An  
Coimisiún  
Pleanála

# Inspector's Report

## ABP-322690-25

<b>Development</b>	Proposed 110kV electrical substation and grid connection
<b>Location</b>	located within the townlands of Friarstown, Grangeford Old, Grangeford, Moanalow, Glenoge, Rathnashannagh, Inchisland Or Moatalusha, Rathtoe, Kellistown East, Ballycurragh and Kellistown West, County Carlow.
<b>Planning Authority</b>	Carlow County Council
<b>Applicant</b>	Prt Solar Limited
<b>Type of Application</b>	Application for approval under Section 182A of the Planning and Development Act, 2000 as amended.
<b>Prescribed Bodies</b>	Carlow County Council Transport Infrastructure Ireland
<b>Observers</b>	Paul Rooney
<b>Date of Site Inspection</b>	25 <sup>th</sup> September 2025
<b>Inspector</b>	Alaine Clarke

Appendix B – Standard 110kV Trench Design – Section through Public Road

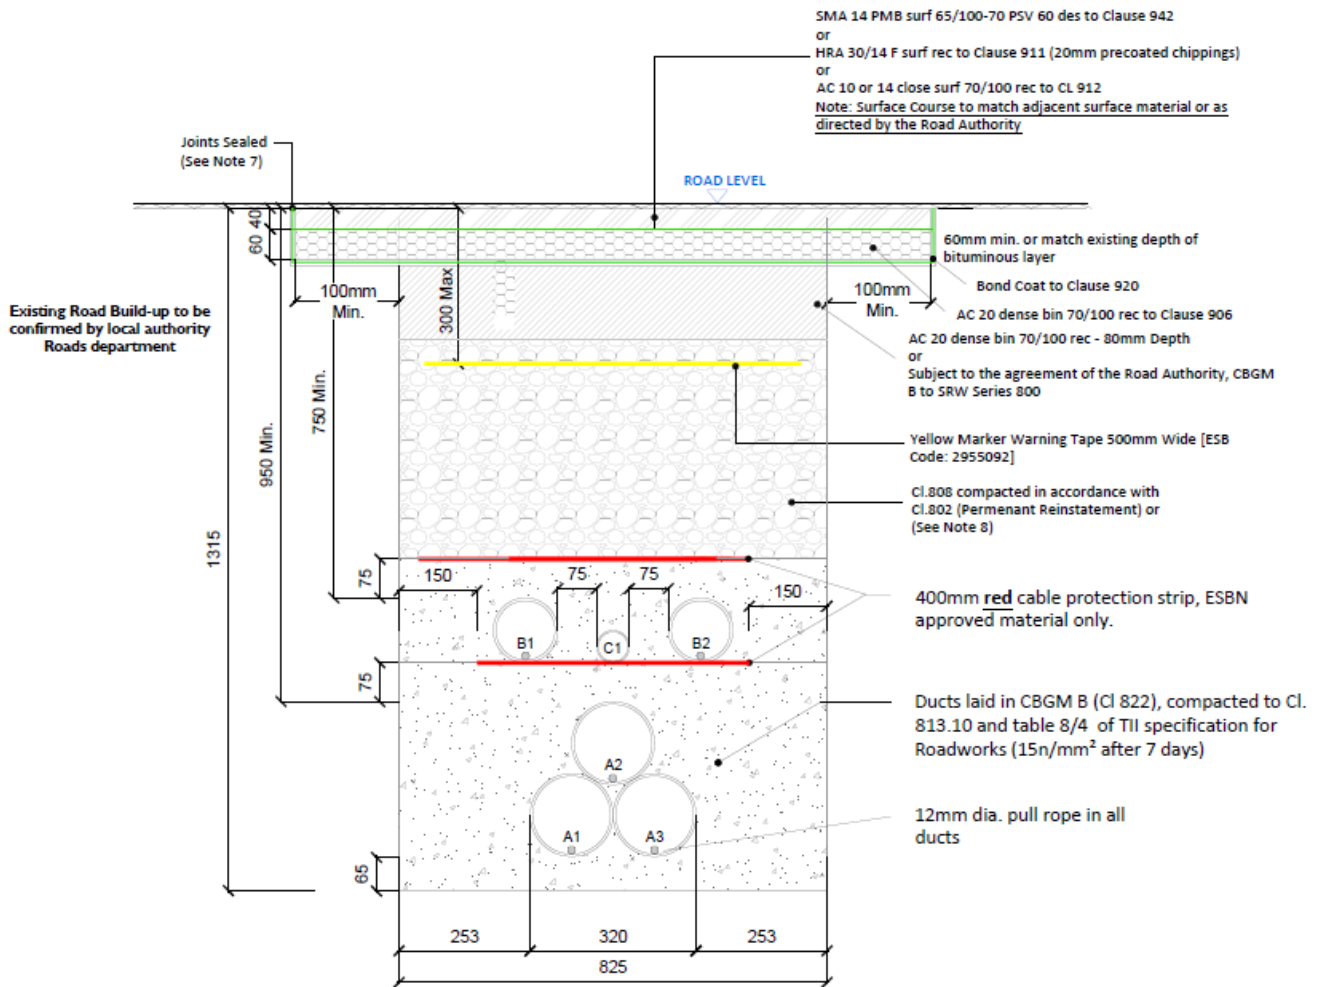
- Municipal District Engineer. Concerns raised primarily relate to impact on roads, traffic and access and include:
    - Why the cables are to be placed in the road; that trench detail for the public road is not acceptable, that no communication chambers, cable joint boxes, shallow ducting or earth link

chambers are to be placed in the public road. That cables should be placed beneath existing services.
